1st REVIEW – DEVELOPMENT PLAN – APPROVED WITH COMMENTS – (CH2018-19-DP-1)
CIMARRON HILLS FIRE PROTECTION DISTRICT

RE: File Number: PPR-1844

The Cimarron Hills Fire Department submitted site development PLOT PLANS to PEAK Consulting Services, Inc. for a fire code compliance review of a proposed site development for the **HAMMERS OFFICE WAREHOUSE** consisting of a new 5000-SQ FT COMMERCIAL OFFICE WAREHOUSE located at 7204 Cole View. The project includes the proposed construction located within the Cimarron Hills Fire Protection District.

1 SITE PLAN SCALE: 1"=20'-0"

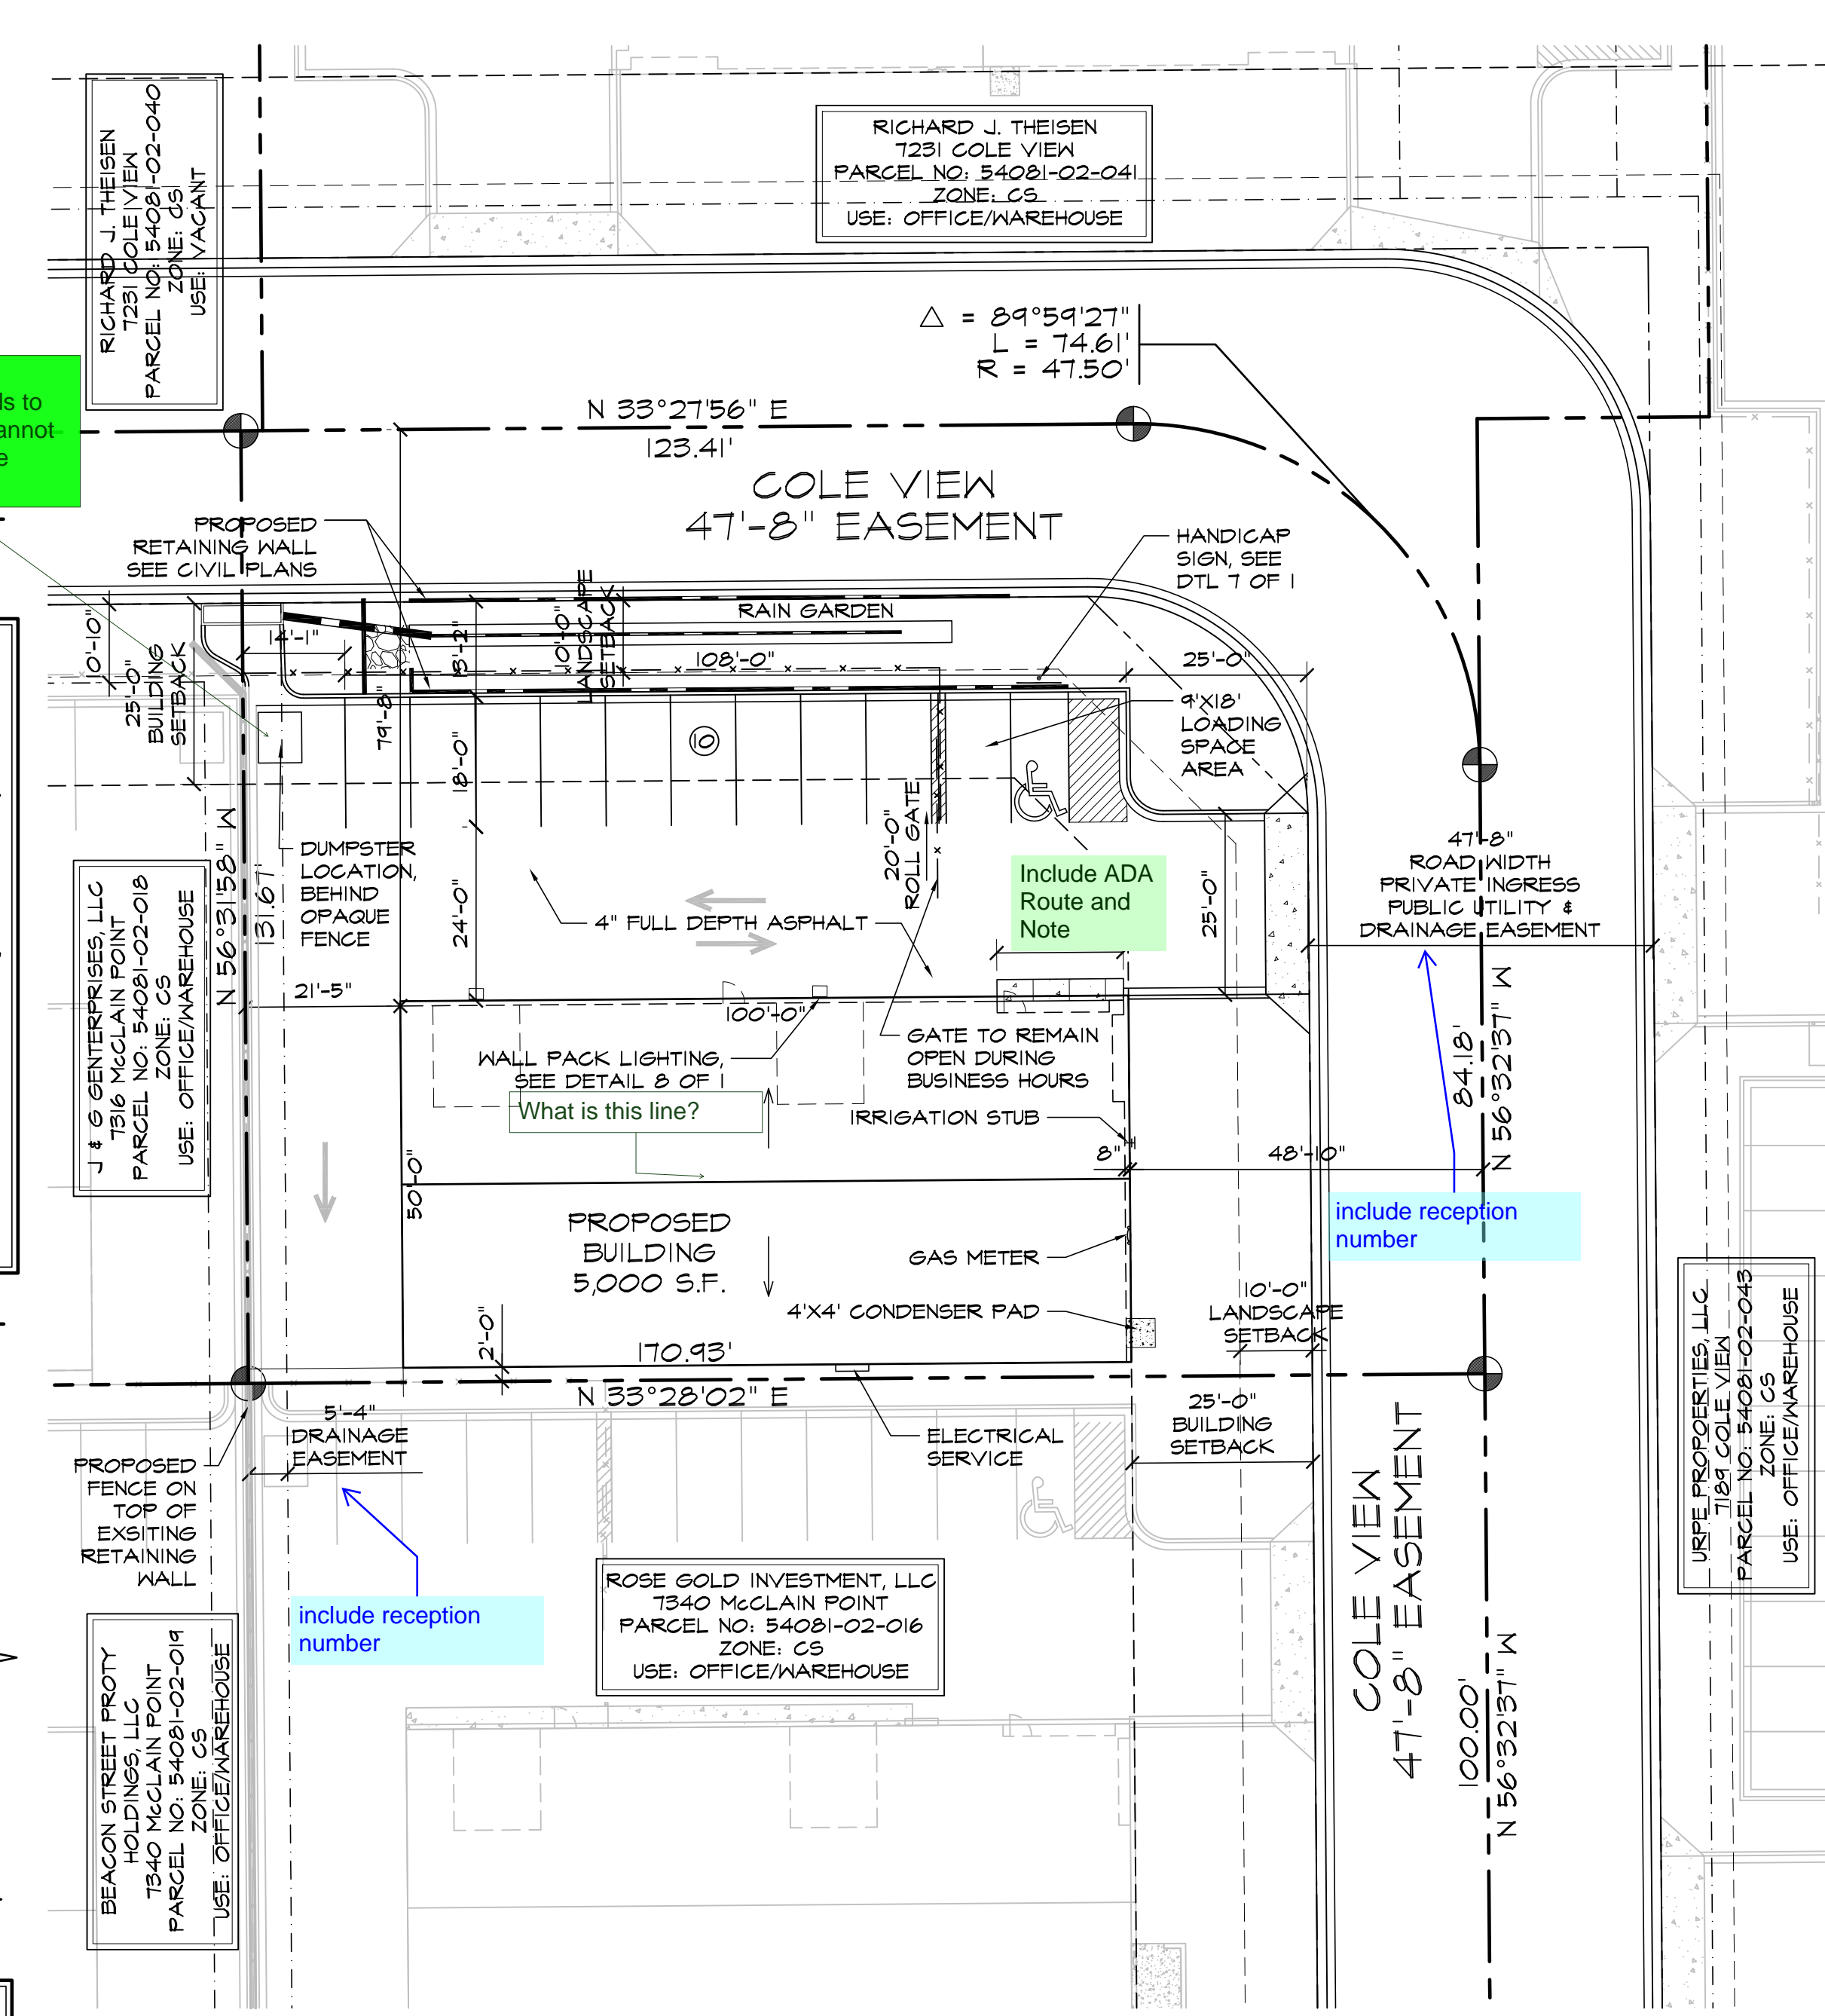
- 1) **FIRE DEPARTMENT ACCESS** –Be advised that the fire code requires that all portions of the exterior of the building be accessible by fire hose line within 150-feet of where a fire truck can park. Be advised that any gate that compromises access to all exterior sides of the building will need to be equipped with a means for fire service access.
- 2) **UTILITY PLANS** – Be advised the utility plan attached to this Site Development Plan does not contain sufficient information to approve the water design (ie construction type, proposed hydrant locations, required fire flow, provided fire flow, etc). Be advised a separate complete water utility plan shall be submitted to the Cimarron Hills Fire District for review and approval.
